For the Attention of Bob Neville 19/02948/F

I enclose a further report from our Consultants on the most recent application above submitted by Rectory. It shows that far from answering concerns, it highlights the fundamental safety issues in this Application.

**REVIEW OF TRANSPORT SUBMISSION
FOR PROPOSED APPLICATION FOR ERECTION OF 10 RESIDENTIAL
DWELLINGS WITH ACCESS OFF SOUTH SIDE INCLUDING A NEW PEDESTRIAN
FOOTWAY ETC P19/02948/F AT
STEEPLE ASTON, OXFORDSHIRE.
ON BEHALF OF
GEORGE DAILEY.**

Plan showing proposed pedestrian infrastructure along South Side

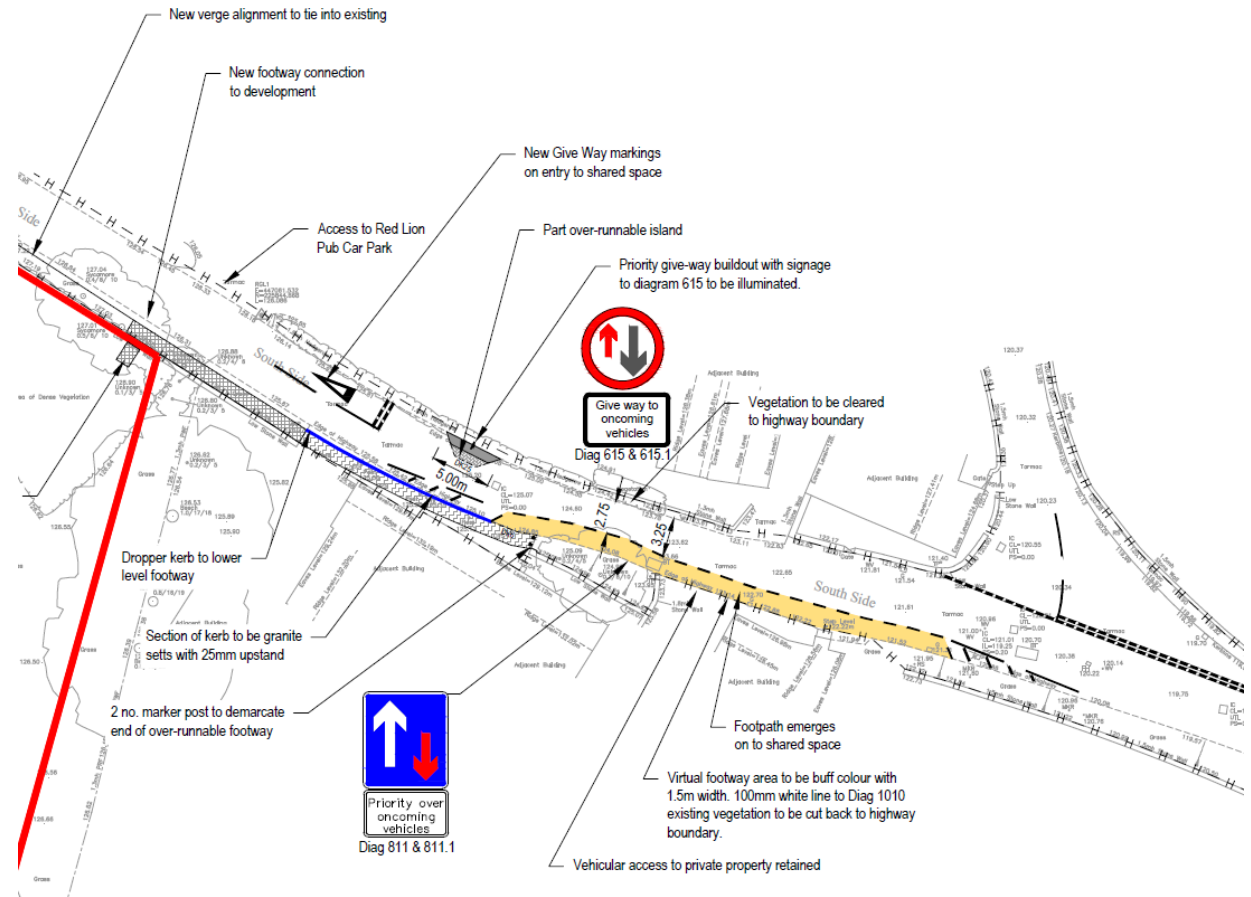
The proposed narrow painted 1.2M surmountable footpath will encourage pedestrians to feel a sense of protection, even entitlement and that is a very dangerous illusion? Anyone who walks with two grandchildren a pram and a dog on a lead as I do, will know that a 1.2M surmountable footpath is insufficient to ensure any degree of safety? Add to that the lack of visibility when they find themselves outside our house looking eastwards? Traffic exiting the village will also be totally unaware of the pres-

It shows a safe or sanctuary area approximately 15 foot by 8 foot outside our front door protected by oak bollards from where pedestrians, families etc can pause, listen and look before stepping out either onto the new proposed stretch of footpath leading down to the junction at Water Lane or continuing their journey westwards. The surmountable build out opposite will need to be relocated nearer to the entrance of the Red lion carpark. Further consideration should also be given to widening the proposed footpath and providing adequate protection by means of a 150mm kerb.

2.4 These are very serious concerns especially in regard of the safety aspects of pedestrians and visitors leaving the house virtually straight in to the new proposed shared carriageway without any warnings or protected area. It is therefore clear that the proposed new shared surface road does not therefore meet the requirements as laid down in the Oxfordshire Local Transport Plan or the West Oxfordshire Local Plan 20131 which states that “safe and convenient routes be served’. With this introduction of the new proposed shared road the pedestrian access point to the house is seriously compromised and compounded further by the many visits every week by Mr Dailey’s small grandchildren.

2.8 The proposed carriageway widths measured accurately by calibrated wheel show widths between 4.3m and 4.9m which are considered insufficient for 2 vehicles to pass each other and this is further compromised by the shared surface. Large vehicles such as the bus-S4- and farm and agricultural vehicles which use this route frequently will be forced on to the side of the road next the front door of Kiftsgate.

2.11 There are no links in terms of pedestrian safety where the shared surface links in with the footway near to the junction of Water Lane with South Side.
